Jean Fraser - 133 York Street

From: Tom Errico <thomas.errico@tylin.com>
To: Jean Fraser <JF@portlandmaine.gov>
Date: 8/23/2013 10:27 AM
Subject: 133 York Street
CC: David Margolis-Pineo <DMP@portlandmaine.gov>, Katherine Earley <KAS@port...>

Jean – I have reviewed the application materials and offer the following preliminary comments.

## Passenger Car at 5 mph, Space 1

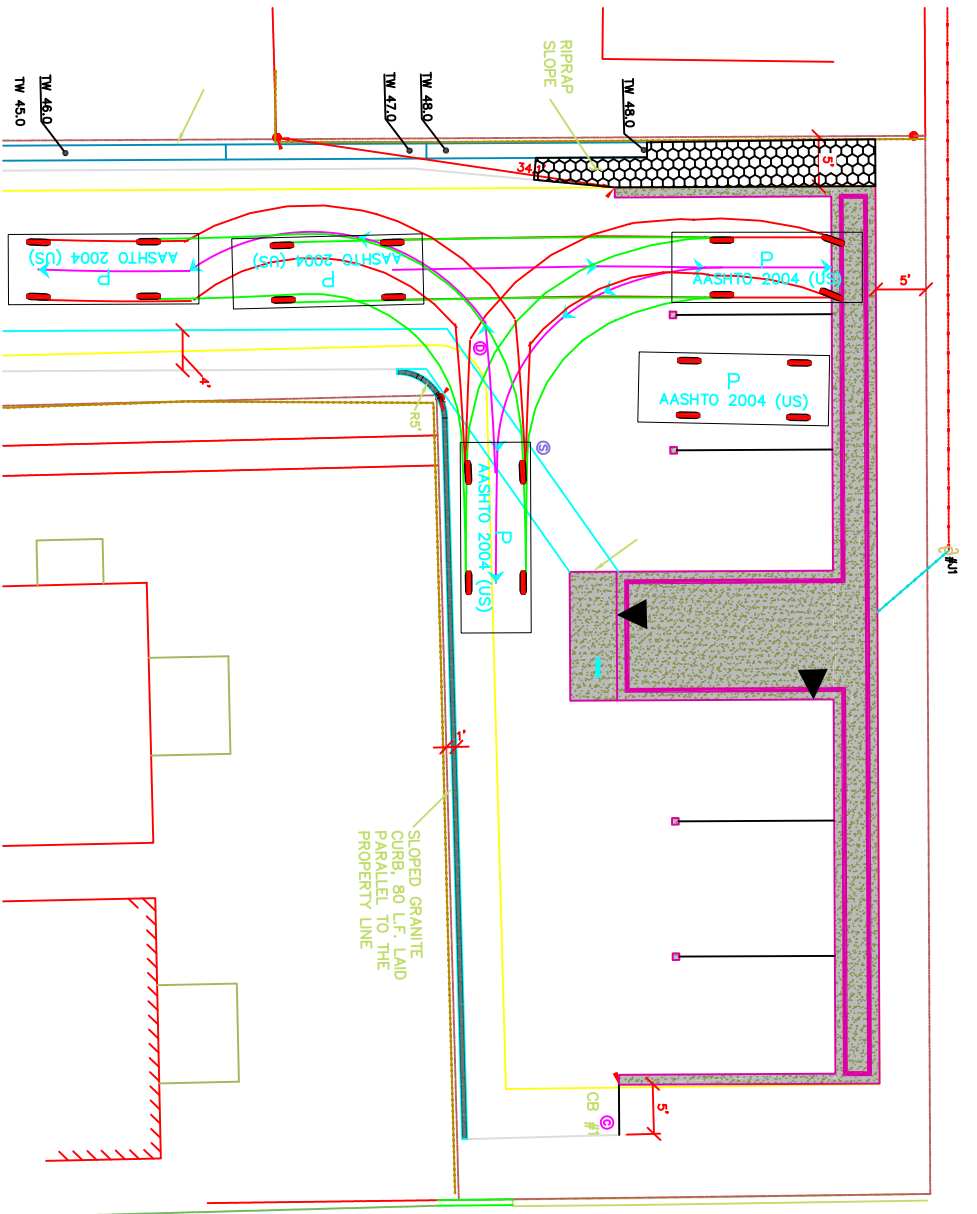
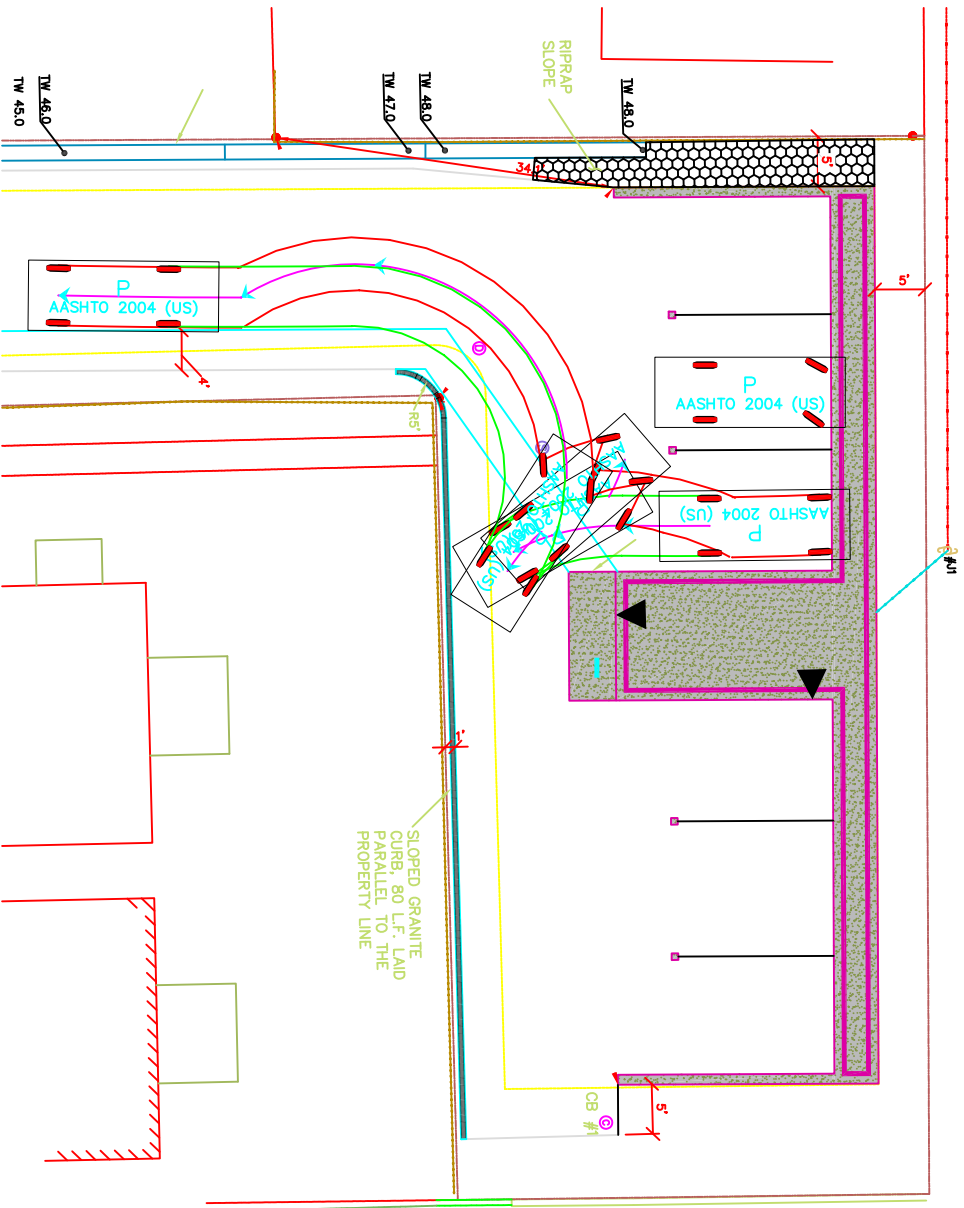
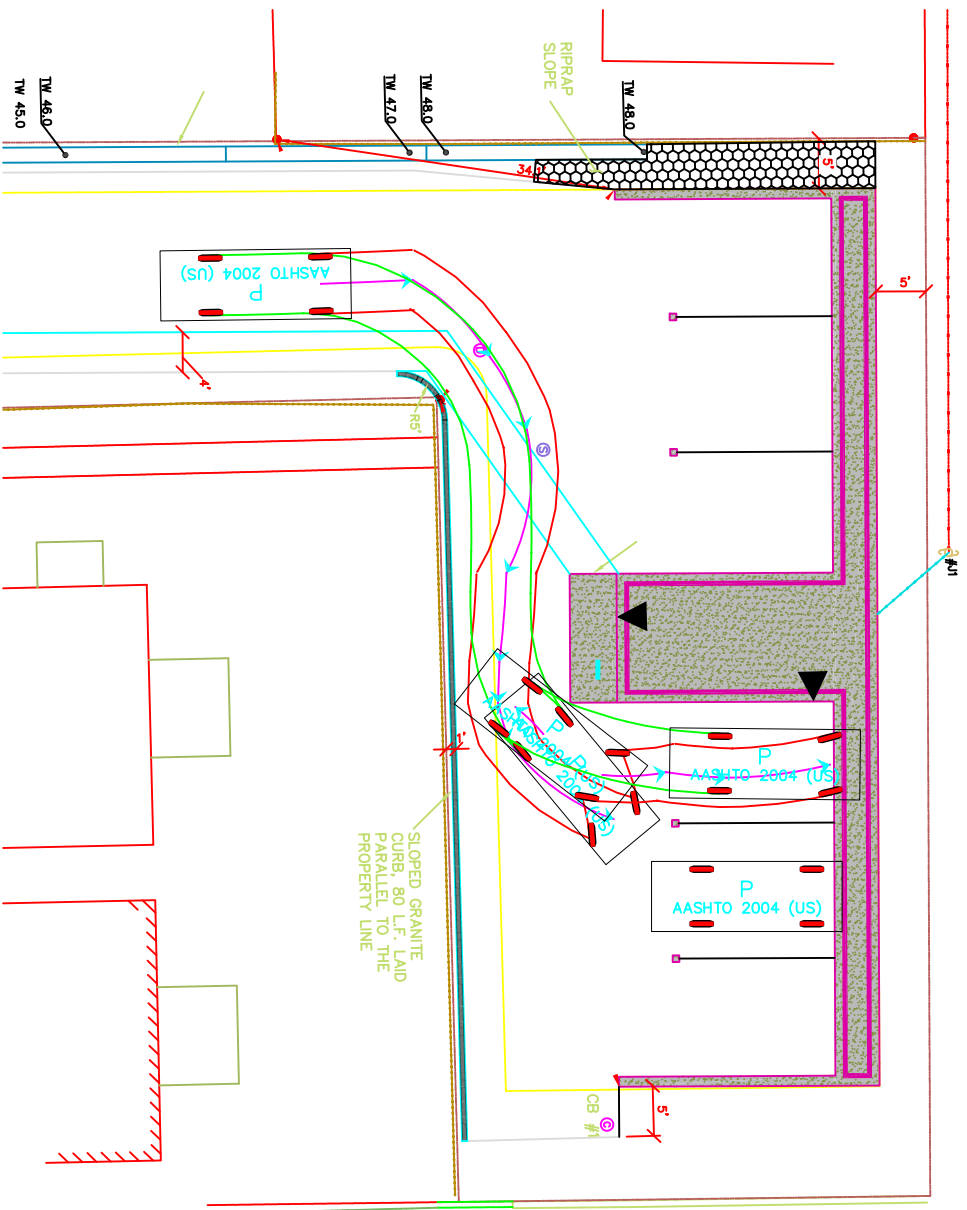
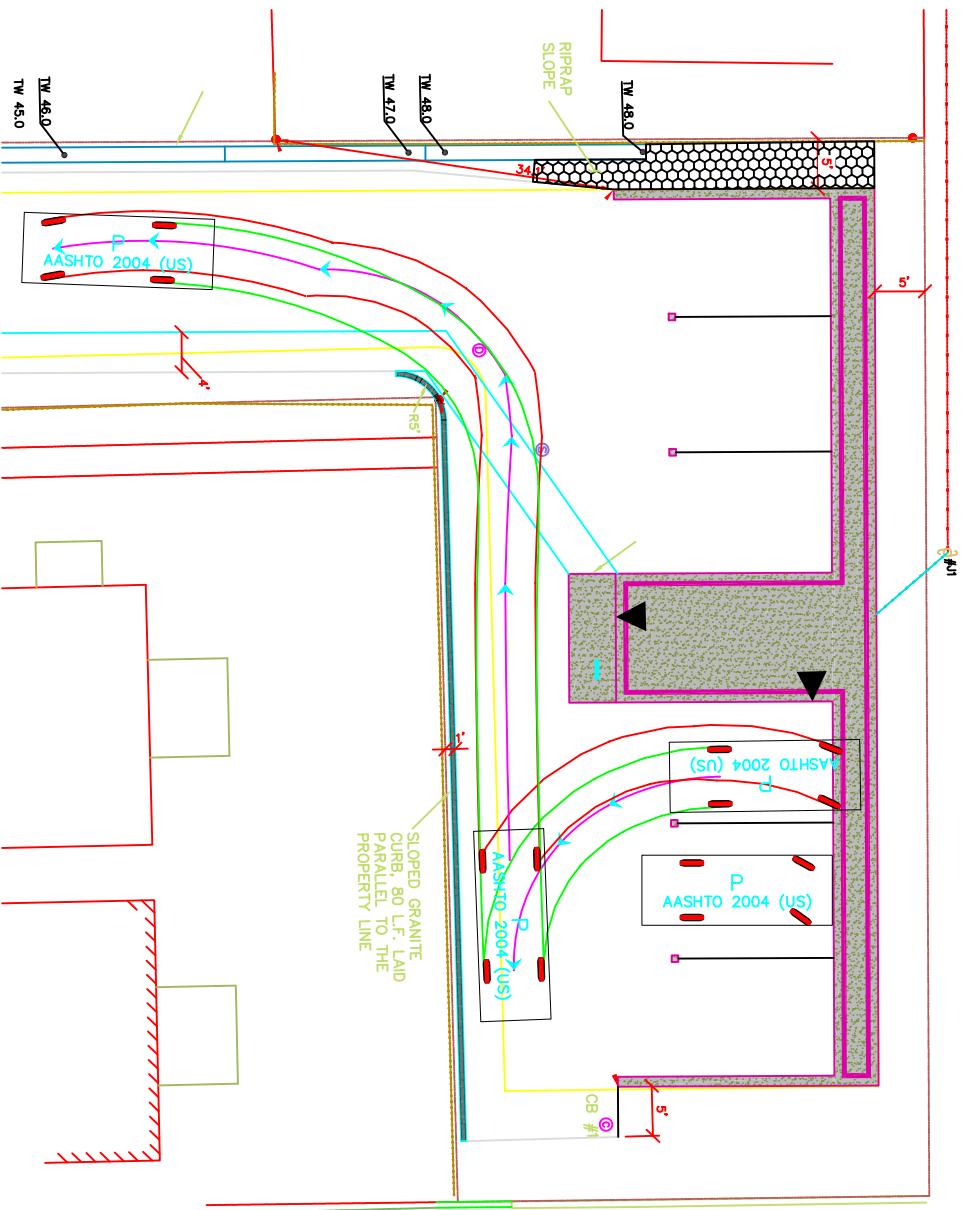
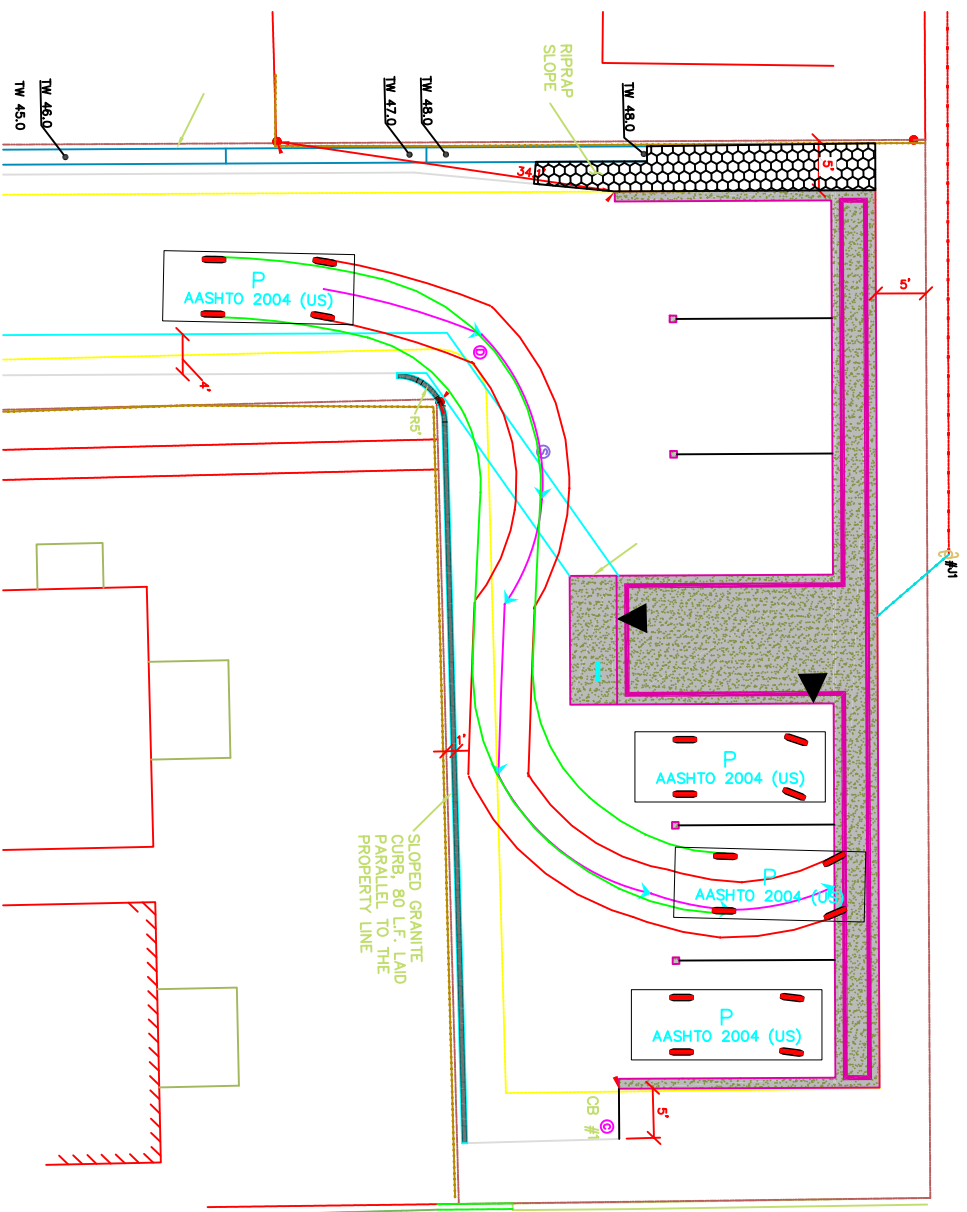
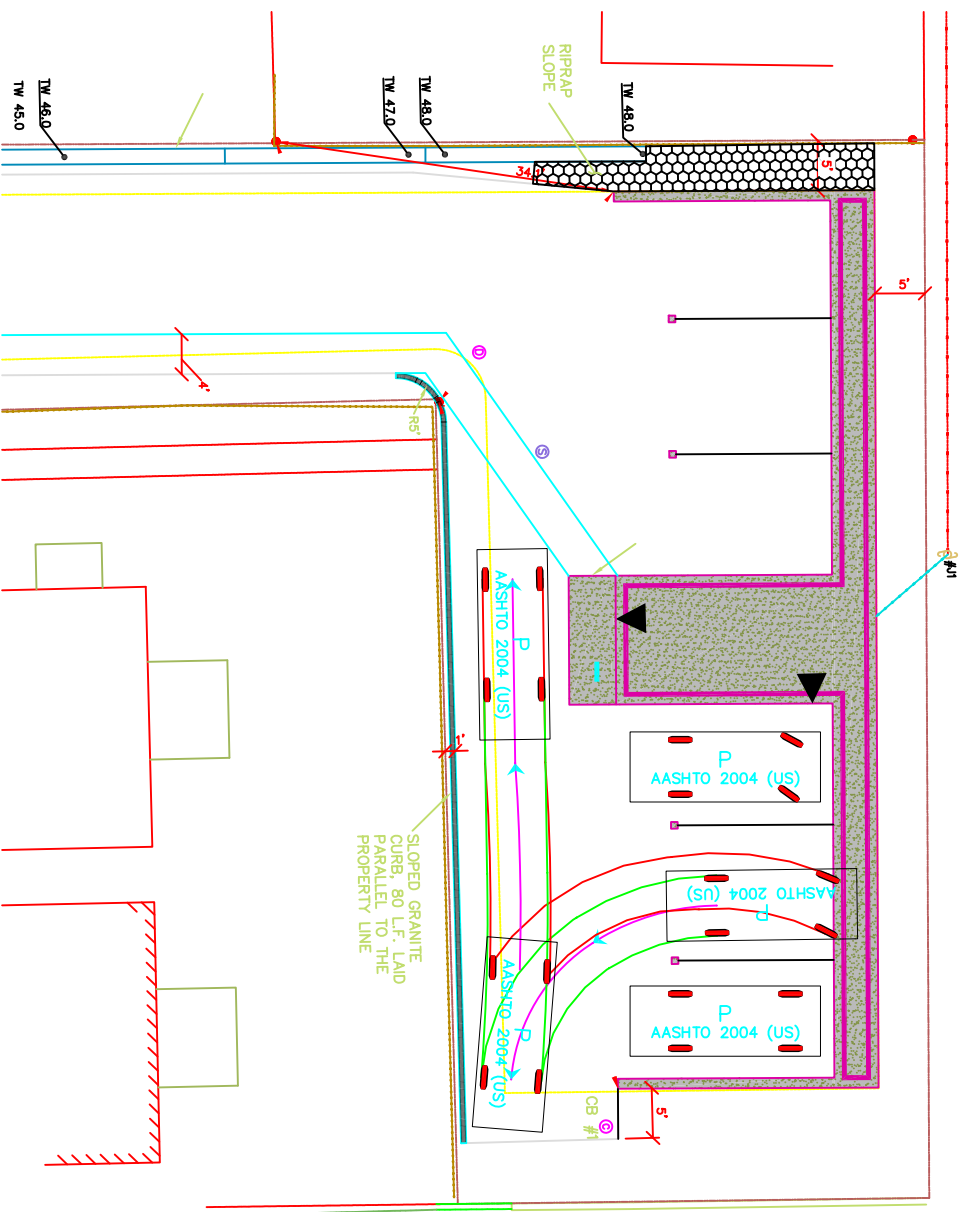
- Access and egress movements into the garages appear difficult given the narrow pavement area. The applicant shall provide turning template graphics for a standard passenger car illustrating the ability of vehicles to adequately circulate on-site.
- Pedestrian movements between the proposed building and York Street should be considered. I would note that I am flexible in the width of the driveway given the size of the development and accordingly a reduction would be acceptable. The City's Technical Standards permit a driveway width of between 10 and 20 feet (it is preferred that the width allow for two vehicles to pass each other particularly at York Street – so I would suggest 16 feet is the minimum width).
